From: Sarah Featherstone [REDACTED]
Sent: 27 September 2019 10:04
To: Anita Gardner <Anita.Gardner@arun.gov.uk>
Cc: Martyn White <Martyn.White@arun.gov.uk>
Subject: Thatch Cottage applications CM/42/19/PL and CM/43/19/L

Thatch Cottage:

West Elevation
SCALE 1=50

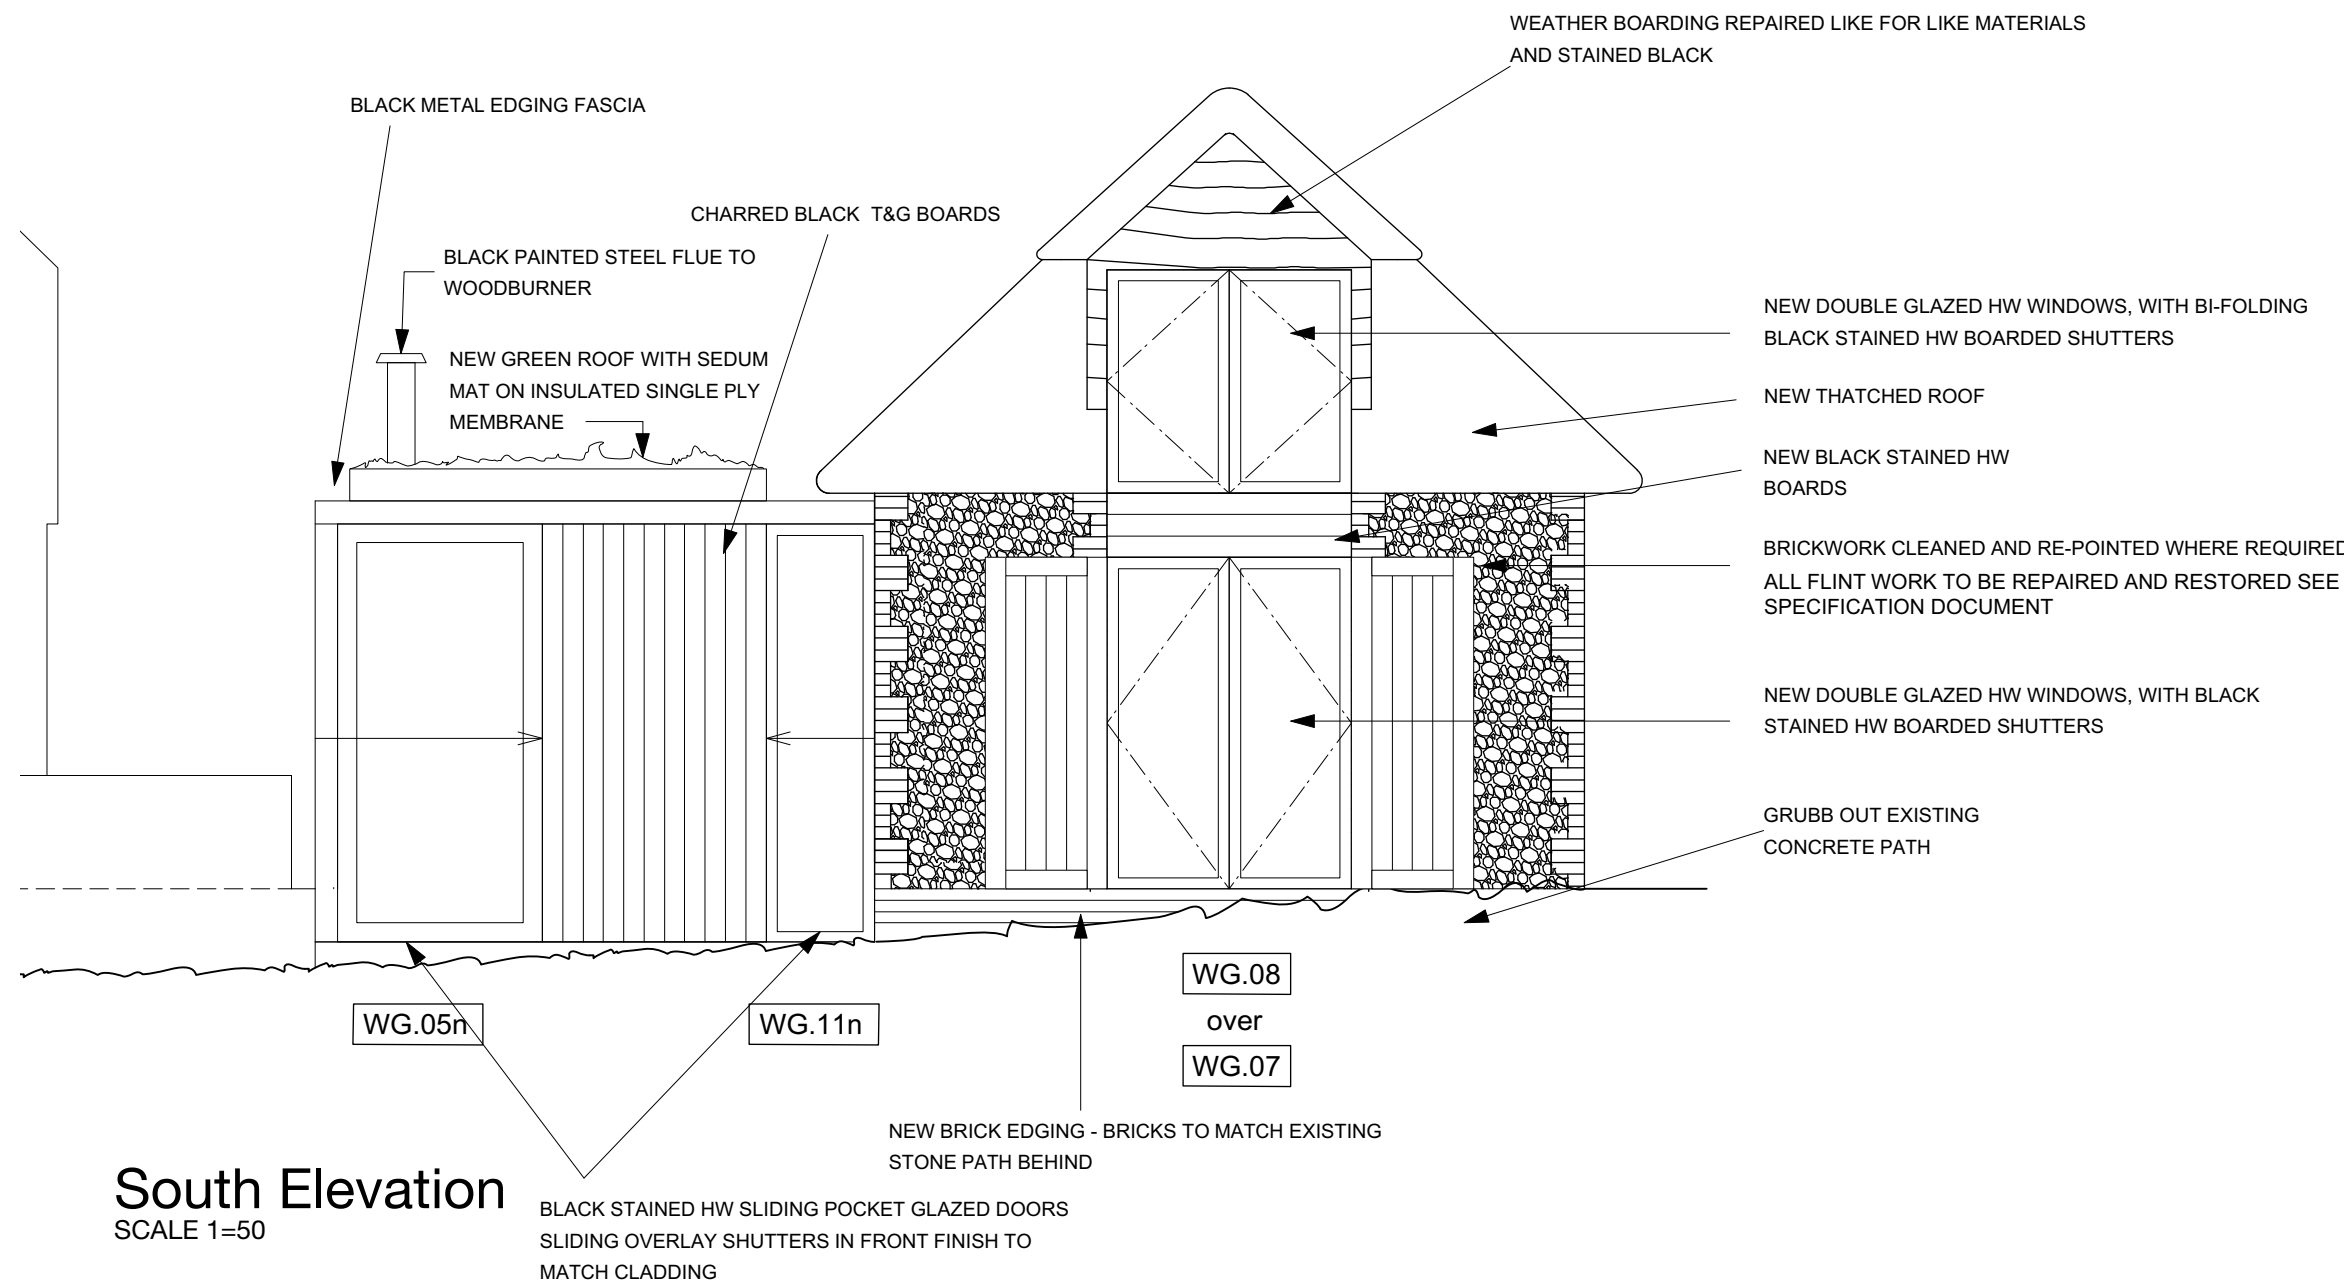
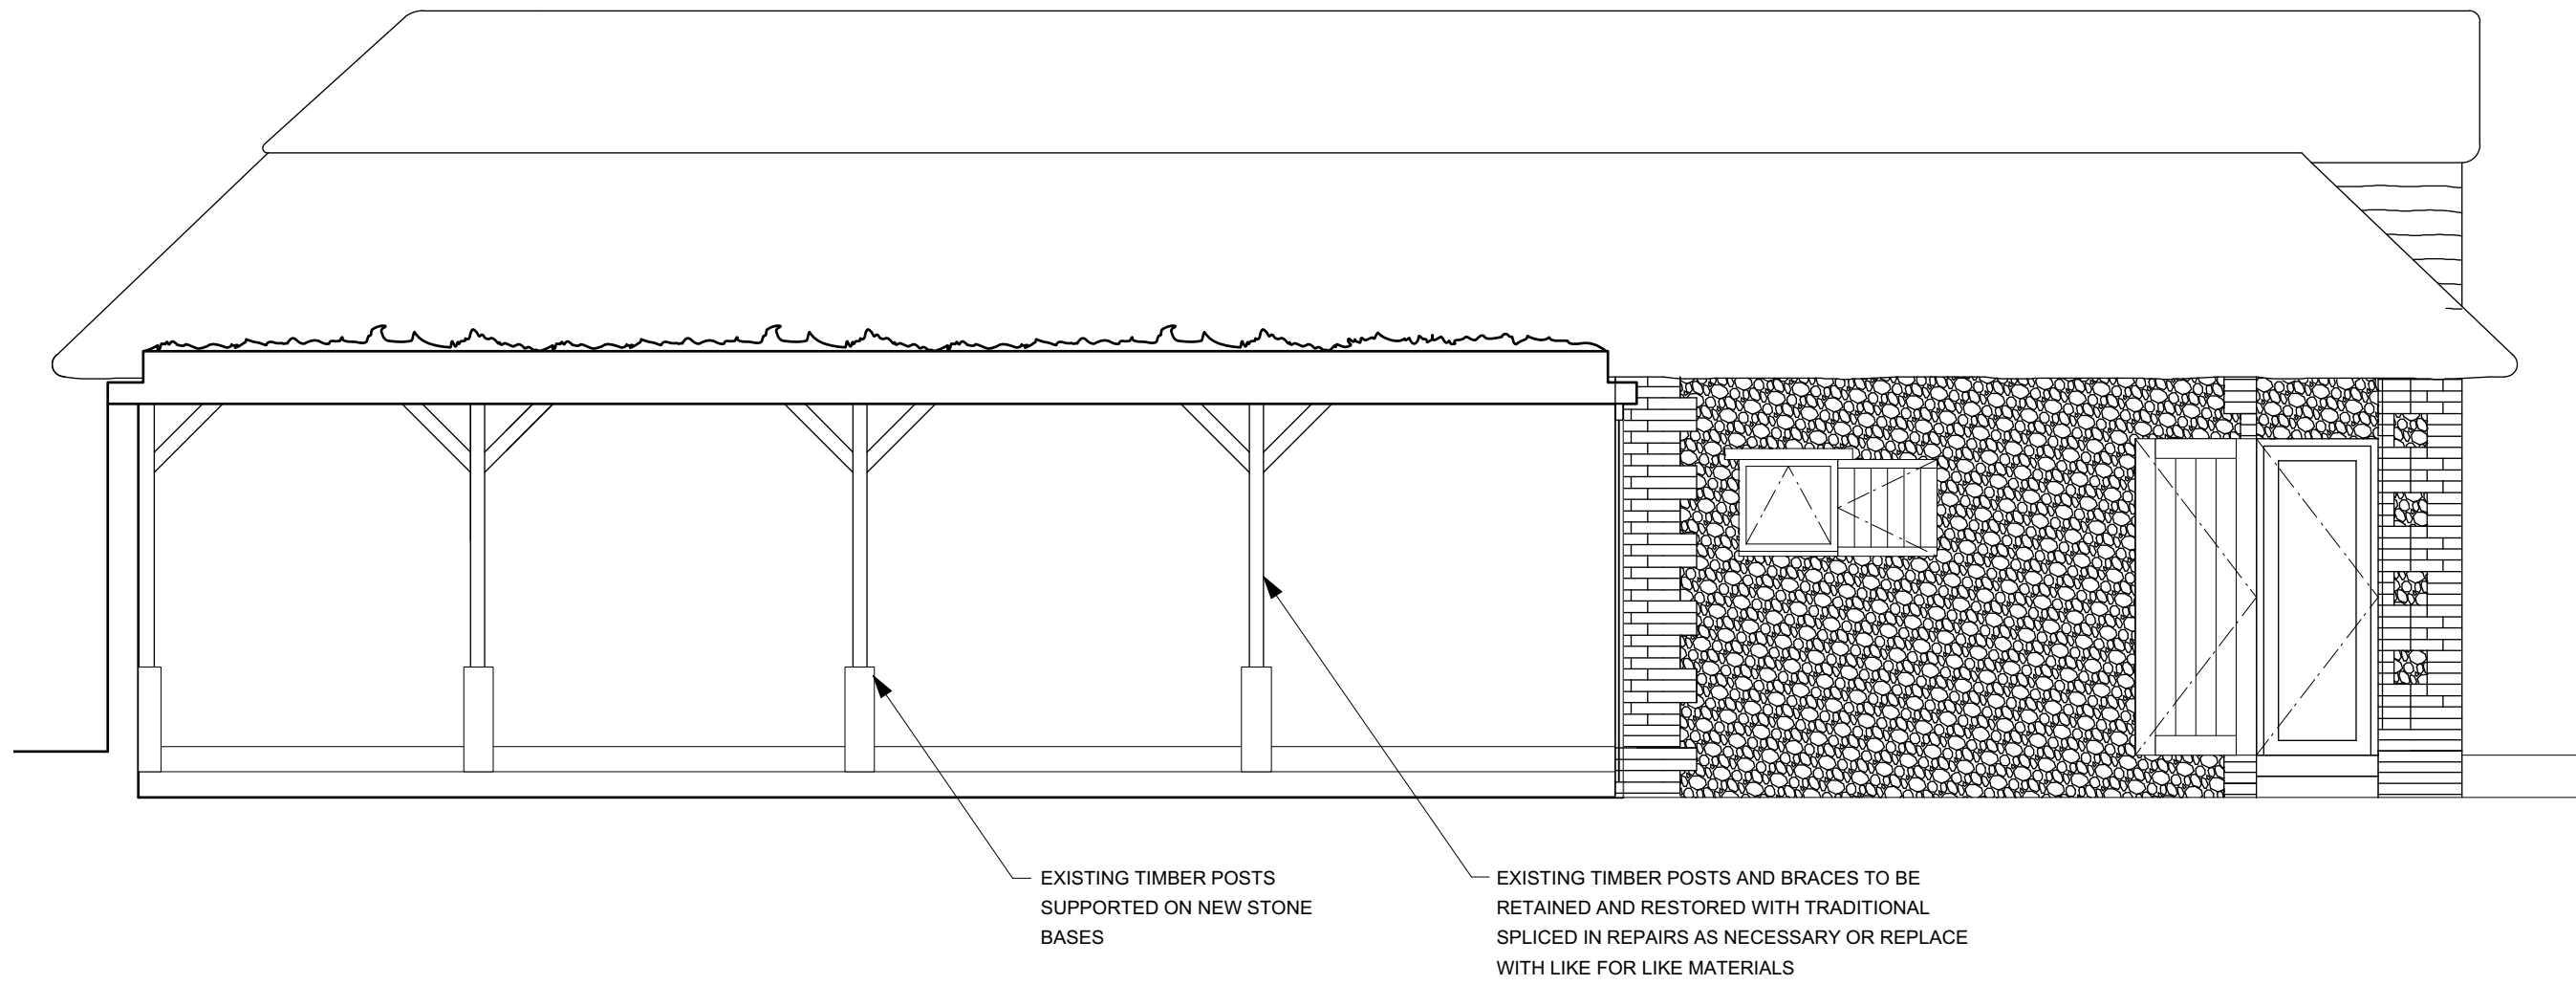
- We confirm all windows have shutters.
- No wall to to edge of southern terrace, there is brick faced side to ramp where it is above grassed ground.
- Private garden - this is not enclosed but Thatch Cottage terraced area opens on to it so we envisage it being used primarily by Thatch Cottage occupants. It will be grassed so we did not think a landscape scheme would be required. Please confirm.
- MW states that the repair and replacement of thatch roof will be acceptable if it reflects those on the existing roof. We can confirm we submitted a Thatch Methodology Statement with the application which confirms the replacement thatch will match what is there on the existing roof. Please confirm no further information is required.
-
- **2. Additional details which we can issue next week:**
- T&G board detail used on external wall cladding of new extension

Detail of Pocket Sliding Door and Overlay Sliding Shutter

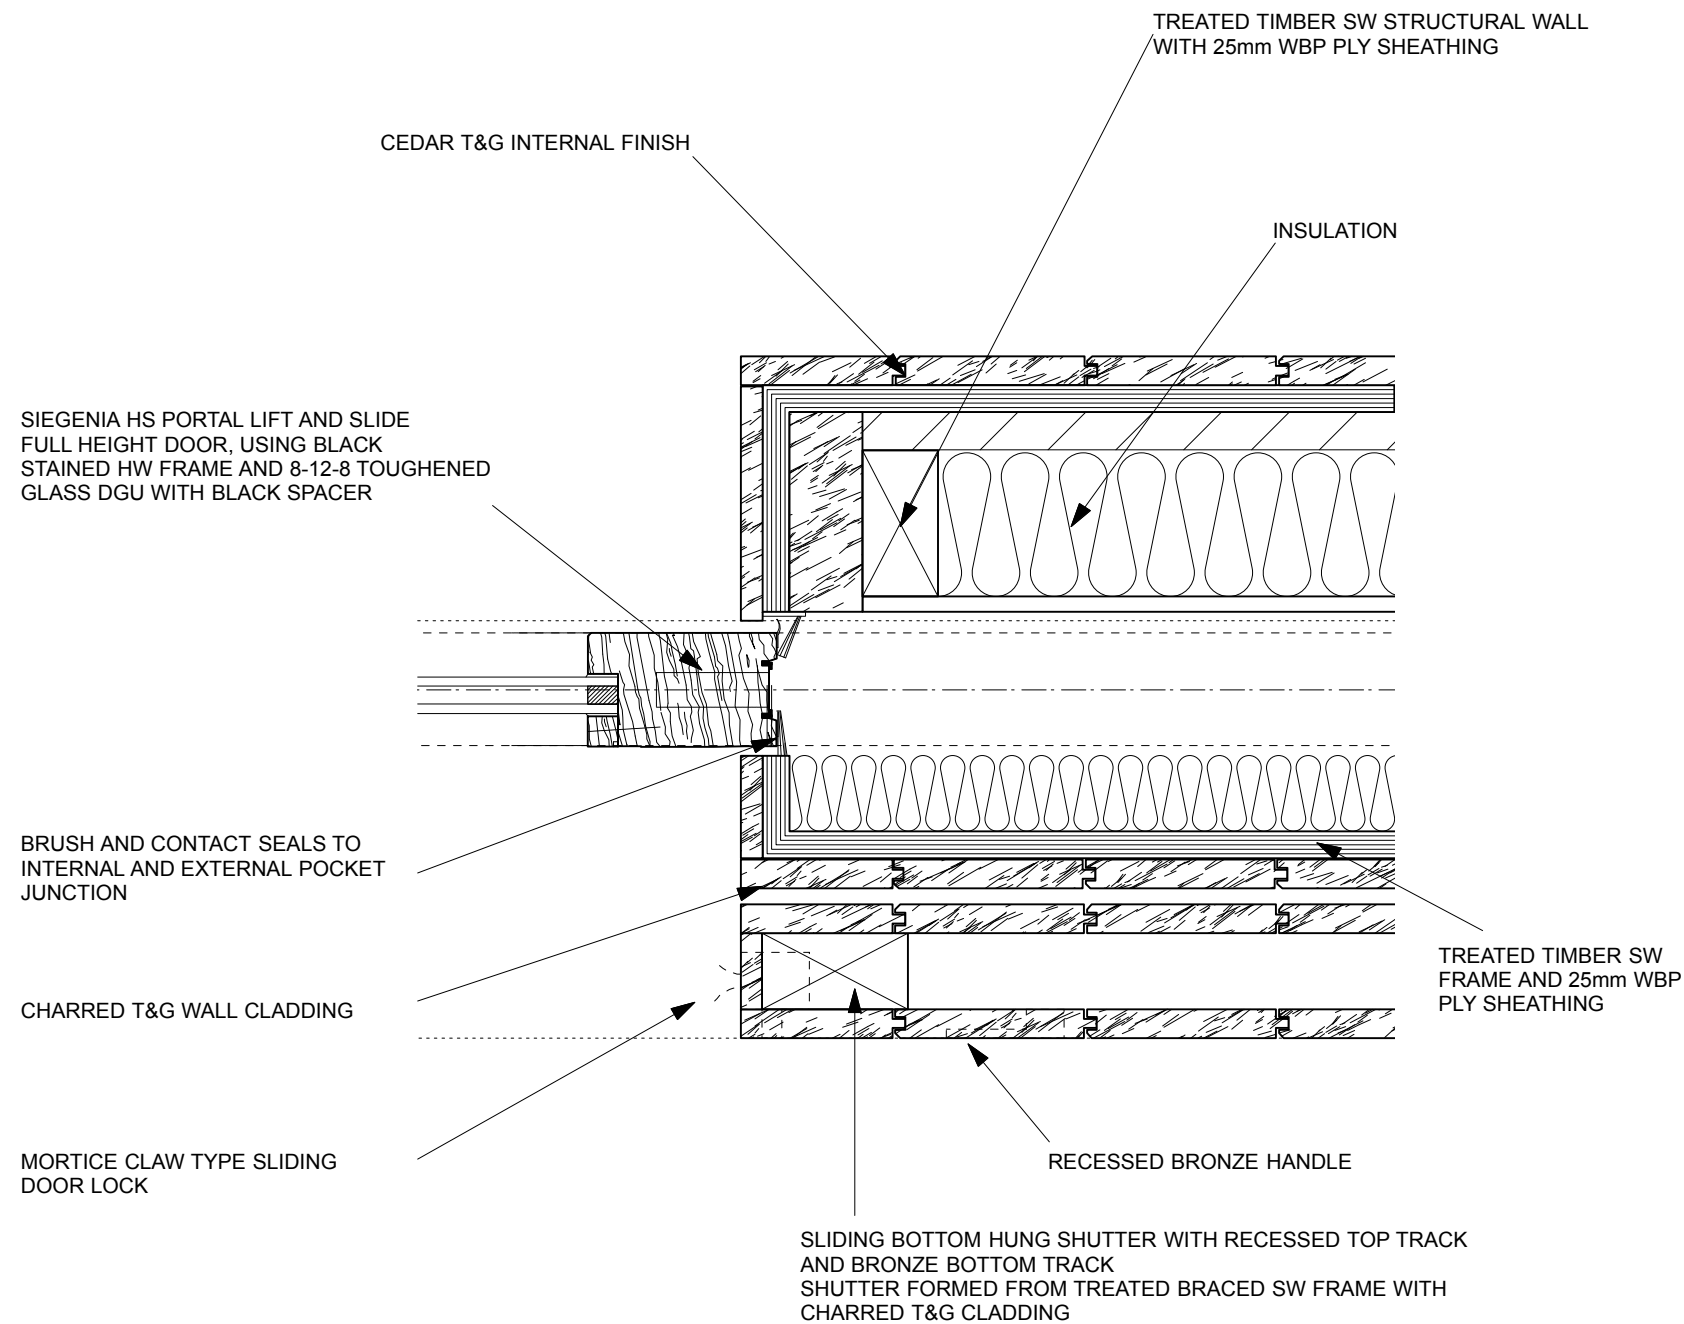
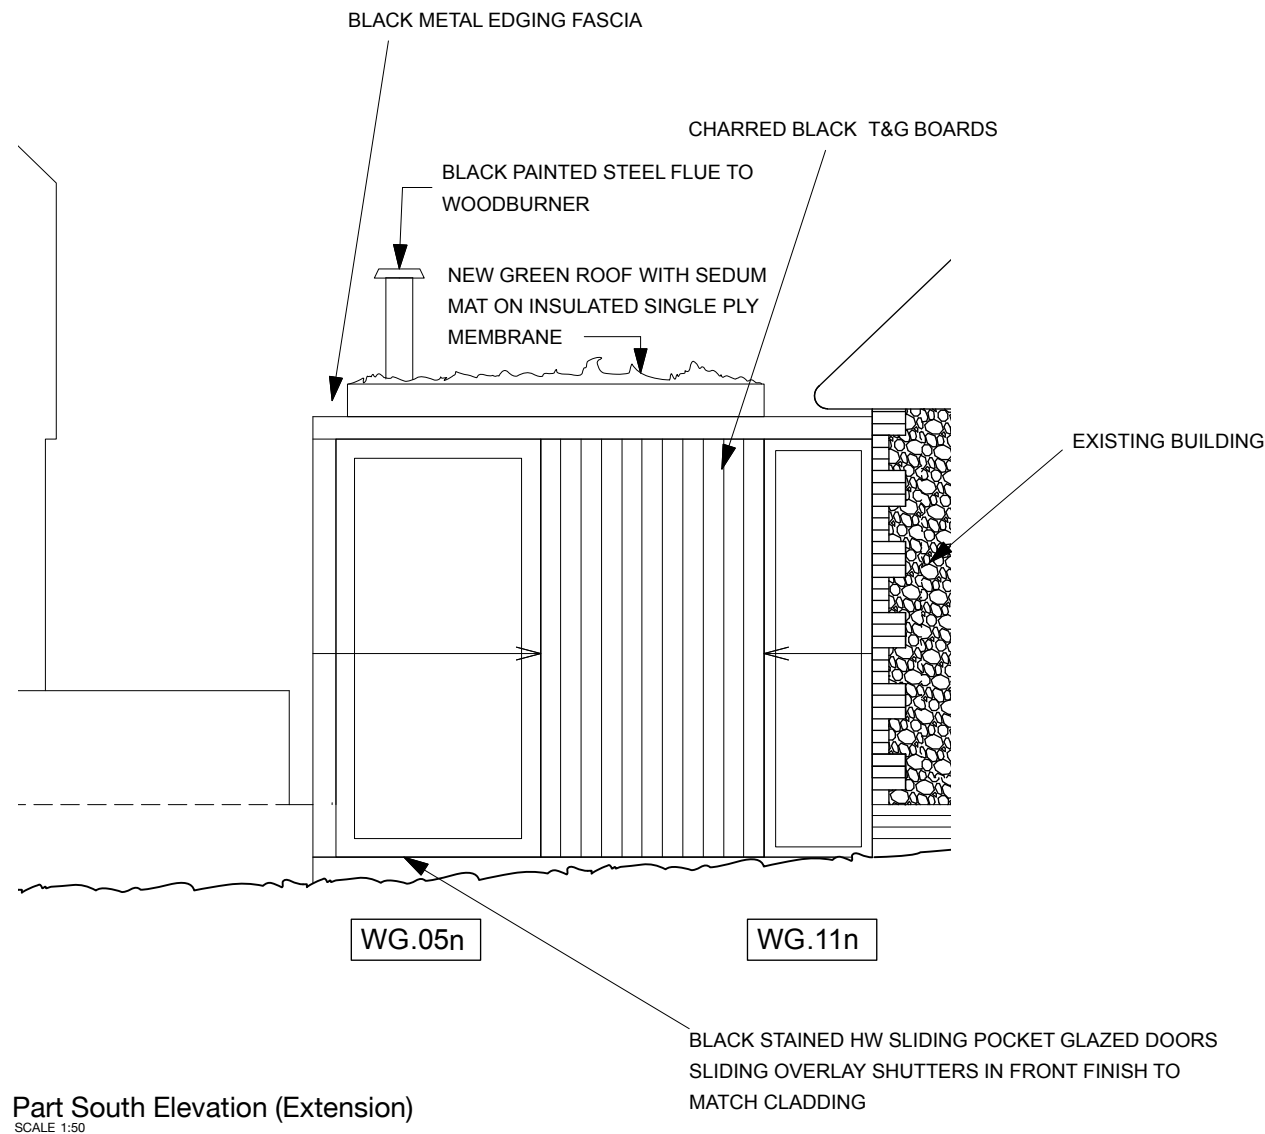
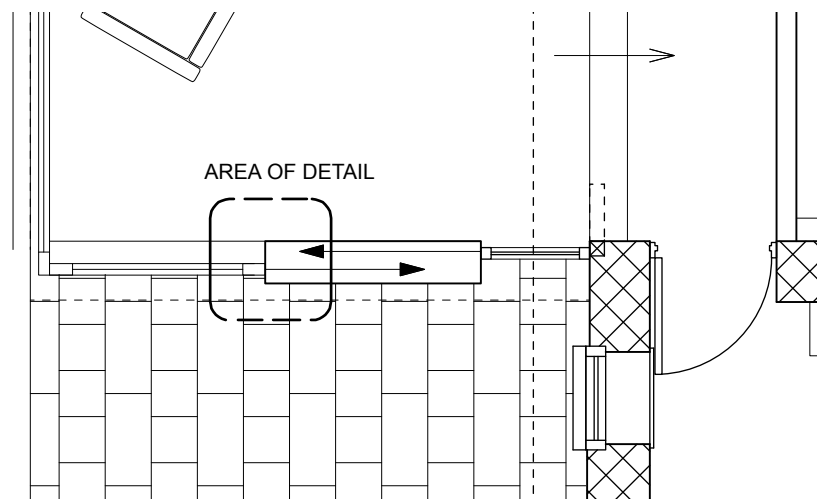
- Shutter details: Window 9 - proposed storm window - we stated "looks better if openings flush with window frame" — MW states "this is matter of detail" . We will provide a detail. Windows 3 & 4 - we understand MW not clear how the shutters operate - they slide in front of external wall. We will provide detail.
- Detail of stone paving specification on external terrace.
- Simple landscape of external garden if required, see note above.
-
- **3. Samples:**
- the side of south terrace ramp is shown faced in brick where it is above grassed ground. The brick will match existing brick quoins. Is it necessary to make up a sample panel for such a small area it is flush to ground at one end and rises above ground to a max height of 300mm at other end?
